Our ref: NO/2022/114604/02-L01
Your ref: 3/2022/0632
Date: 26 January 2023

**THE APPLICATION IS FOR DEMOLITION OF EXISTING BUILDINGS AND
ERECTION OF A CARE HOME (USE CLASS C2) OF UP TO 70 BEDS. ALL
MATTERS RESERVED APART FROM ACCESS.
PENDLE MILL PENDLE ROAD, CLITHEROE, BB7 1JQ.**

Environment Agency position

Existing and Proposed Site Section A-A

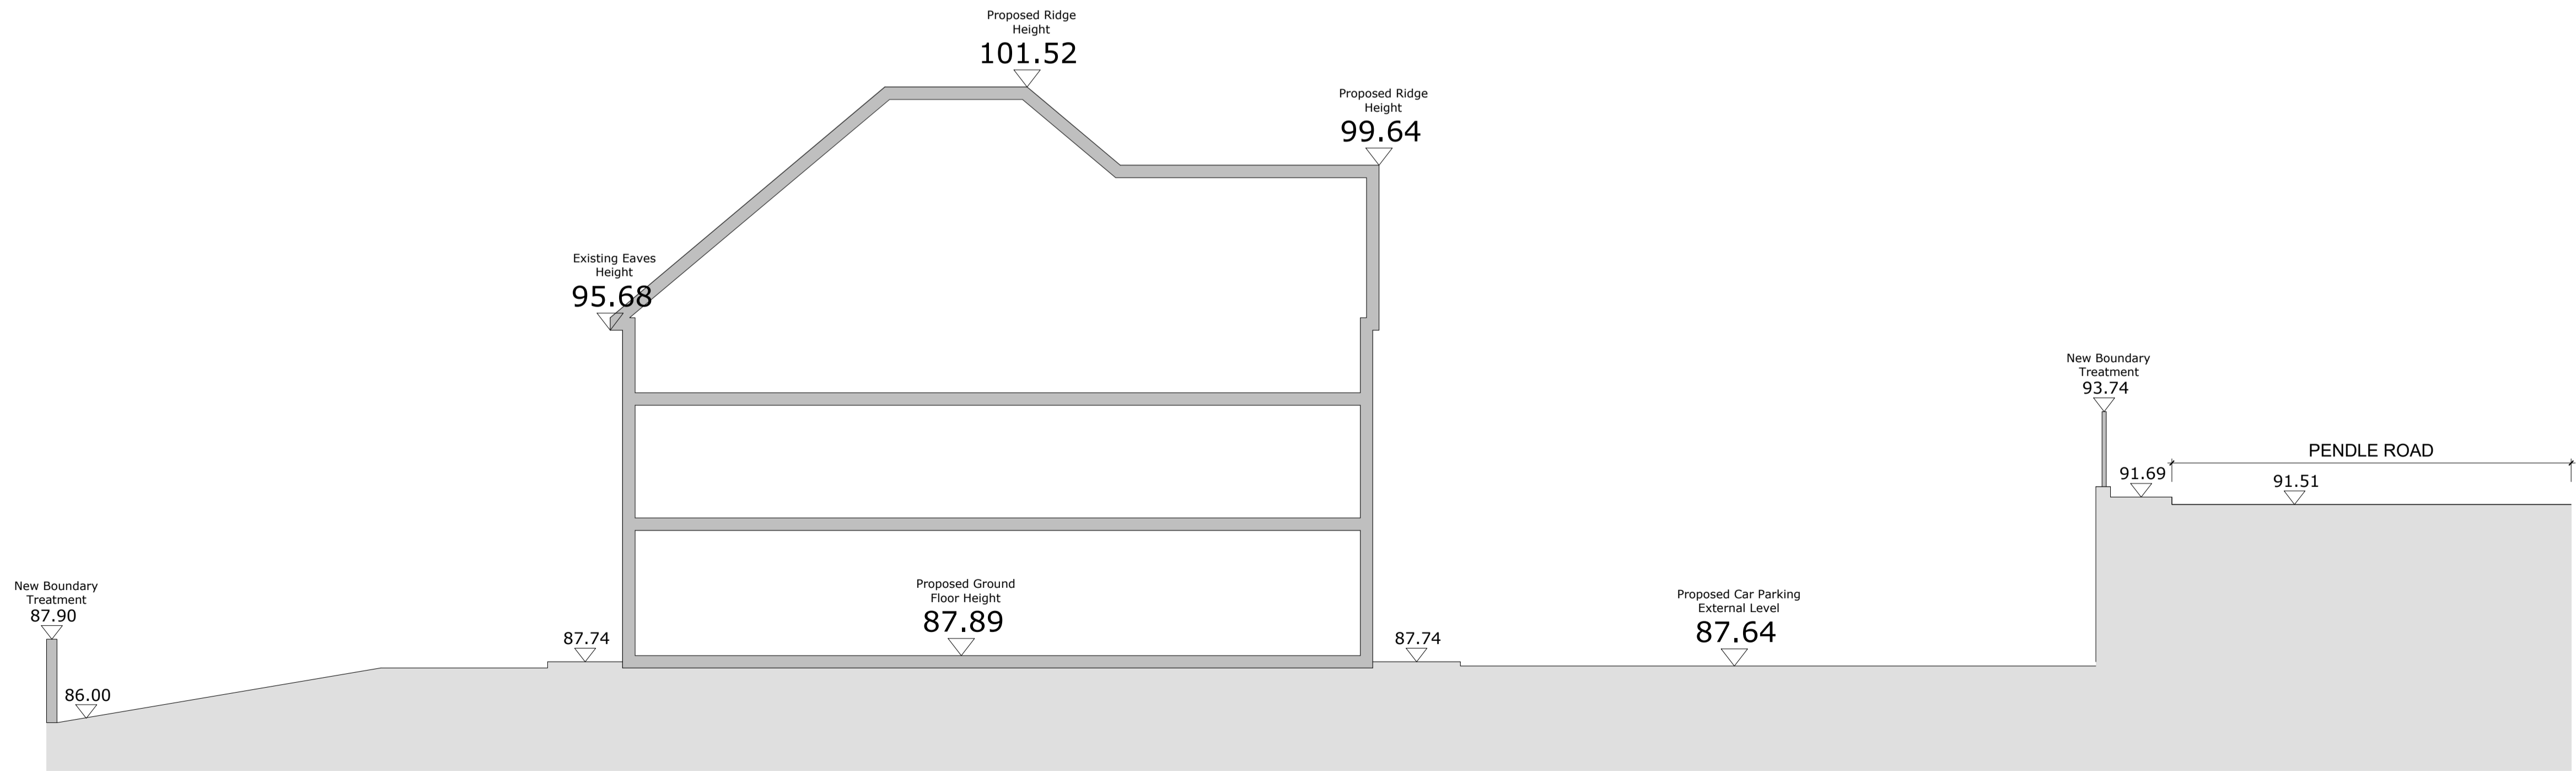
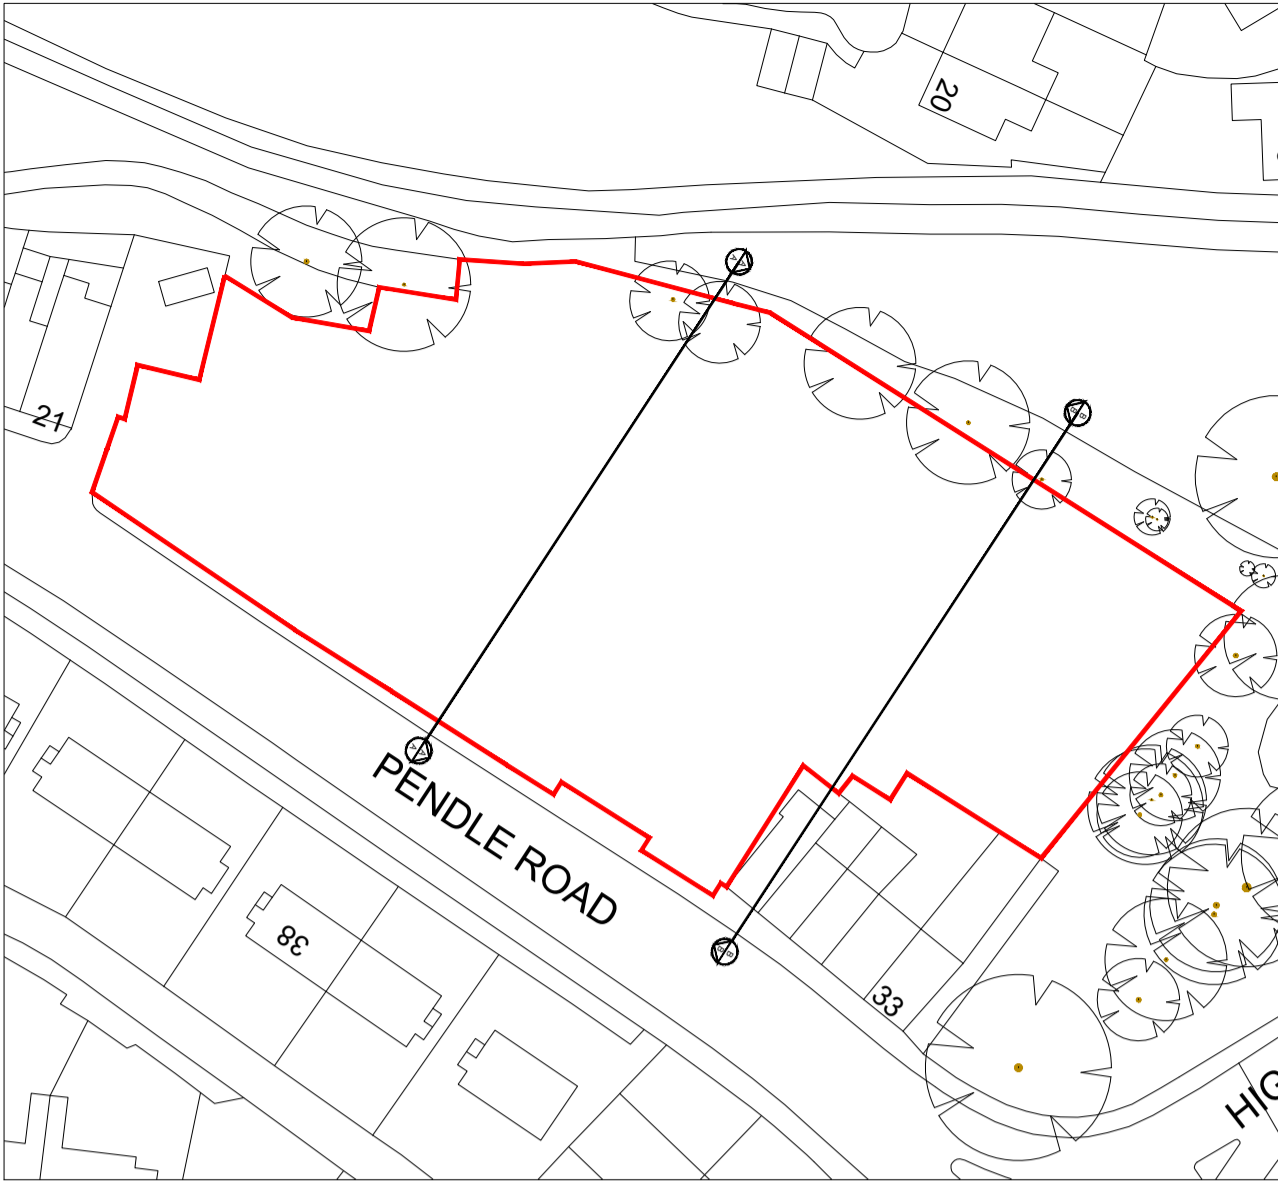
In our letter referenced NO/2022/114604/01-L01, dated 28 July 2022, we objected to the development proposed, due to a discrepancy between the recommendations and conclusions of the submitted Flood Risk Assessment (FRA) and Drainage Strategy prepared by bEk Enviro Ltd., referenced; BEK-22035-3, dated May 2022, and the drawing ref, "*Existing and proposed site section A-A*", H.21.78 (9-) 20.

This discrepancy has now been rectified and the current revision B, now agrees with the proposed Finished Ground Floor Height level of 88.78m AOD, as recommended in the FRA. As a result, we now remove our objection to the development subject to the inclusion of the contaminated land condition indicated below.
